Planning Application Ref: FP/223/20/T

Location: 12 Grafton Avenue, Felpham, PO22 6AR

Description of works: Reduce 1no. yew tree (T1) to height 8m and spread 6m. Fell 1no. yew tree (T2)

Reason given: Structural damage (garden boundary wall)

Photographs of T2 and crack in wall

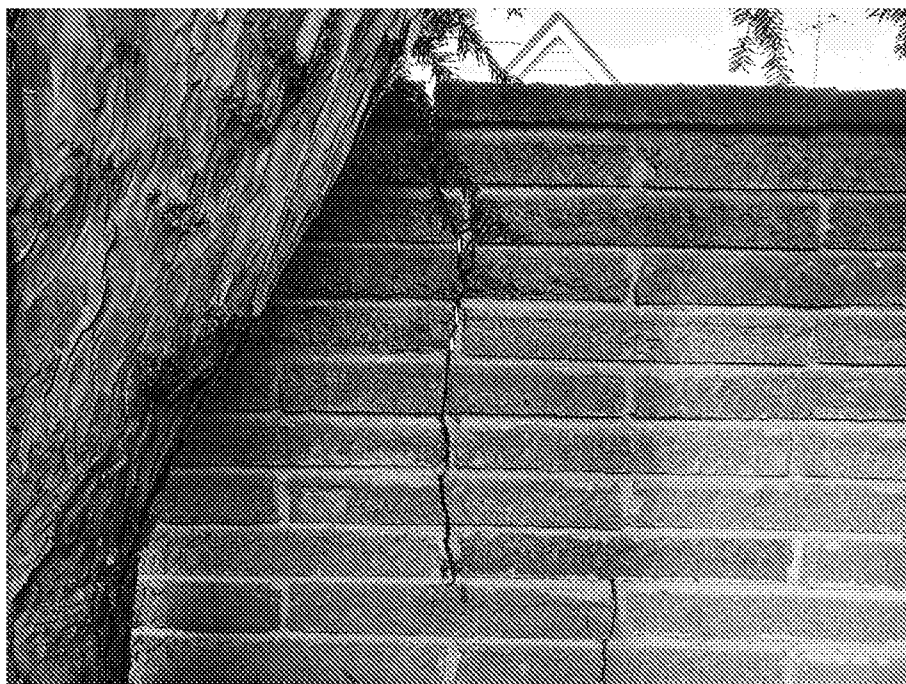
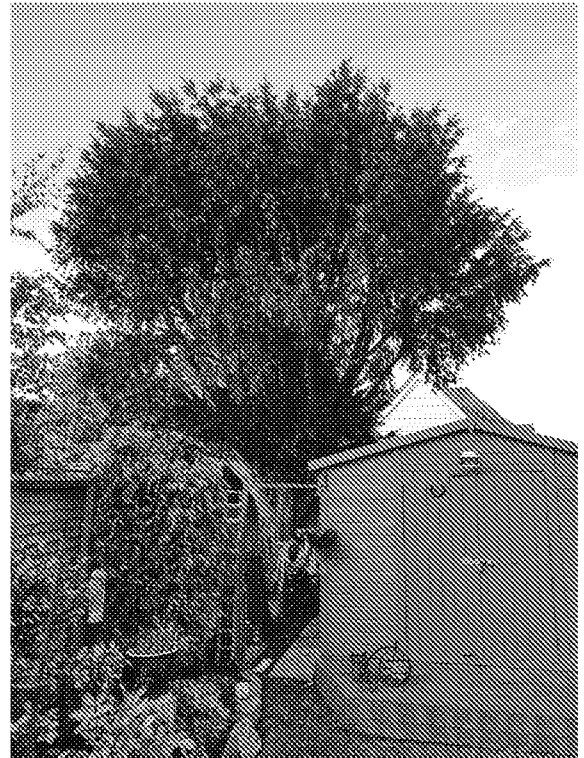
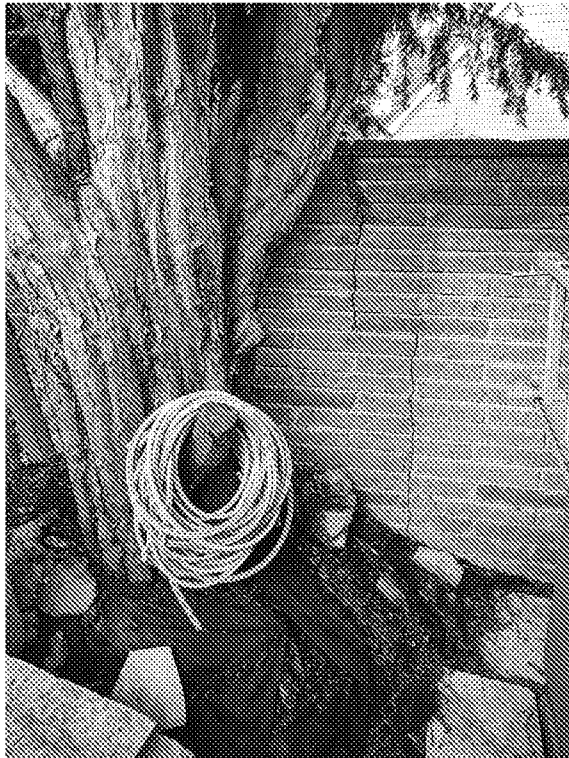
- I have considered this application by means of a desktop review, using the plan and photos submitted as well as online resources.
- The applicant currently has a valid Approval (subject to conditions) for specified reduction in height and crown spread of both trees, under planning reference FP/49/20/T. This application replicates the approved work proposal for T1. T2, the southern specimen, is proposed for removal. It is implicated in an ongoing damage event to a garden boundary wall.

- T1 - The proposal to reduce its overall height and spread with a view to restricting its growth is justified and consistent with previous works approved by the Local Planning Authority.
- While a temporary loss of aesthetic value is inevitable, satisfactory canopy renewal and recovery should occur if the work is undertaken to a high standard and at an appropriate time of year.
- T2 – The removal of this tree has been justified as necessary to achieve long-term structural integrity of 3rd party boundary wall. A replacement tree of a more suitable type and planted at an appropriate distance from boundary structures is achievable and can form part of the decision notice.

Once the tree (T2 Yew) has been felled (and either grubbed or ground out) then a replacement tree is to be planted in the same place or nearby and to within 3metres.

This is to be of Standard Nursery Stock proportions (10-12cm girth & 2m to 3m overall height) supported on a 'short stake' system with appropriate securing ties and pads.
